SPACE VILLAGE FILING NO. 4
A PORTION OF THE NW 1/4 OF SEC. 17, T14S,
R65W, OF THE 6th P.M., EL PASO COUNTY, COLORADO
GRADING & EROSION CONTROL PLAN

SPACE VILLAGE FILING NO. 4
EL PASO COUNTY, CO

SHEET TITLE:
GRADING & EROSION CONTROL
COVER SHEET (SWMP-SITE MAP)

SHEET TITLE:  
GRADING & EROSION CONTROL  
NOTES (SWMP-SITE MAP)

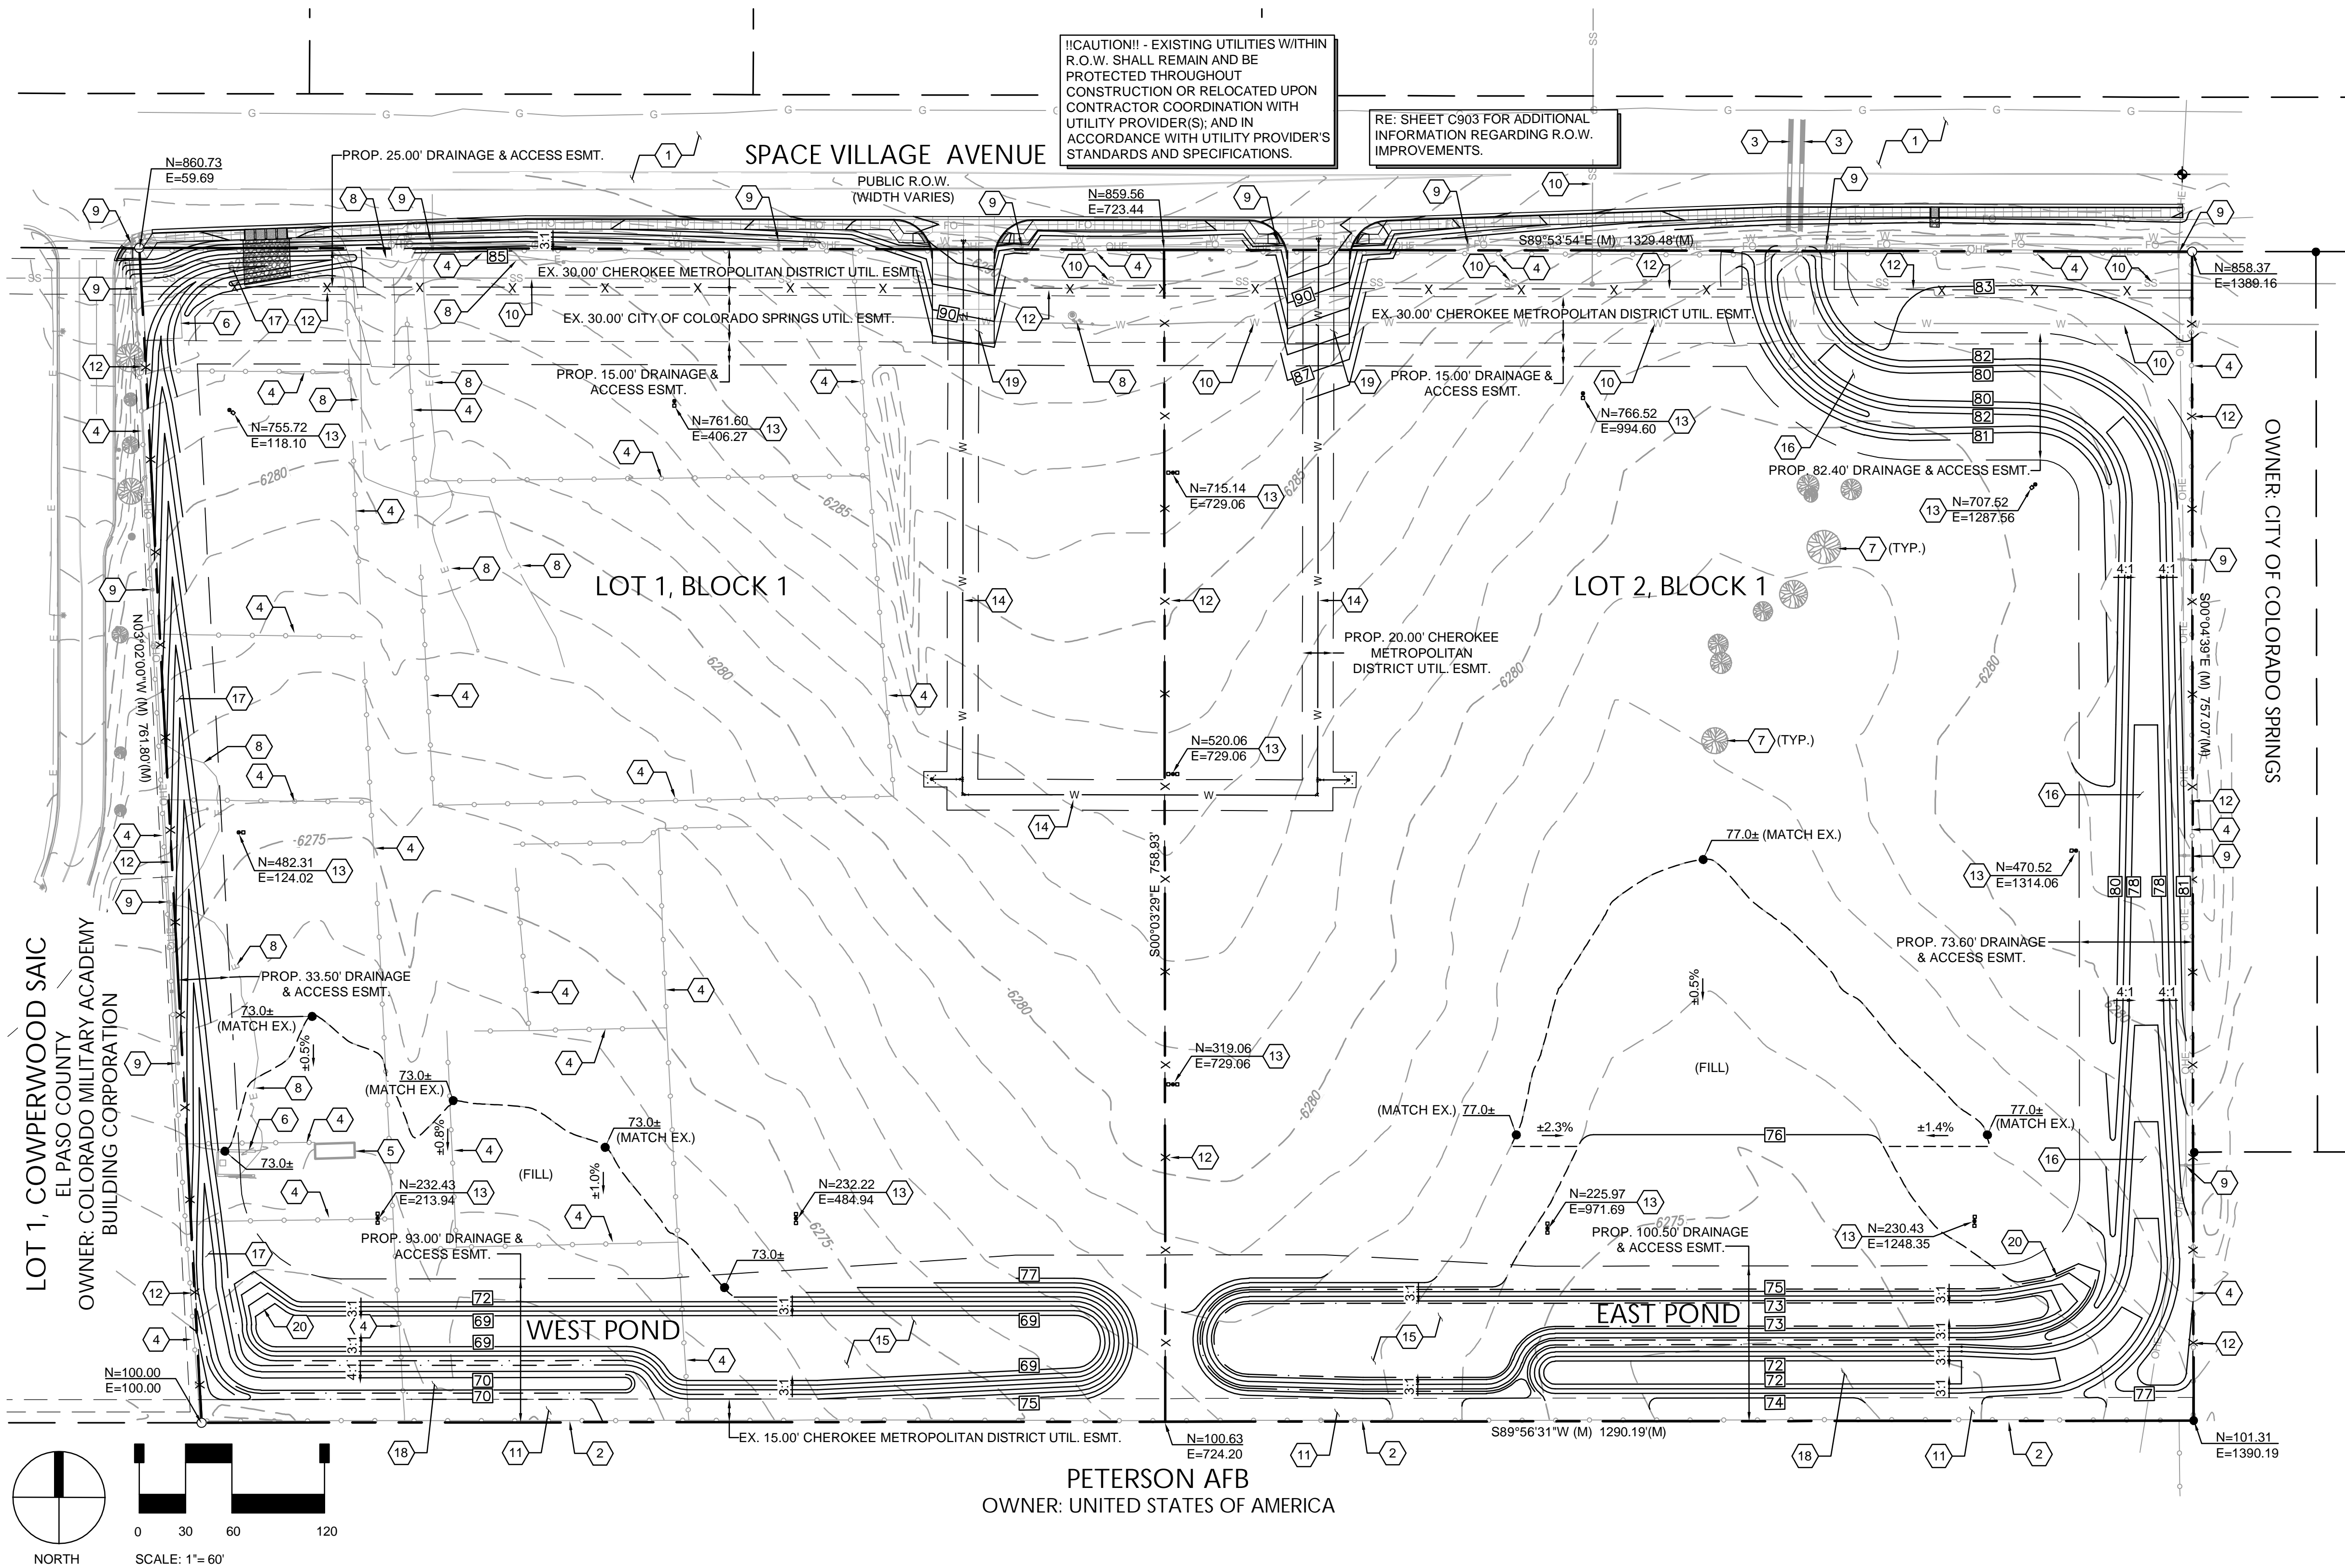
Please remove "El Paso County" from the heading on this page as these are not standard notes by El Paso County.
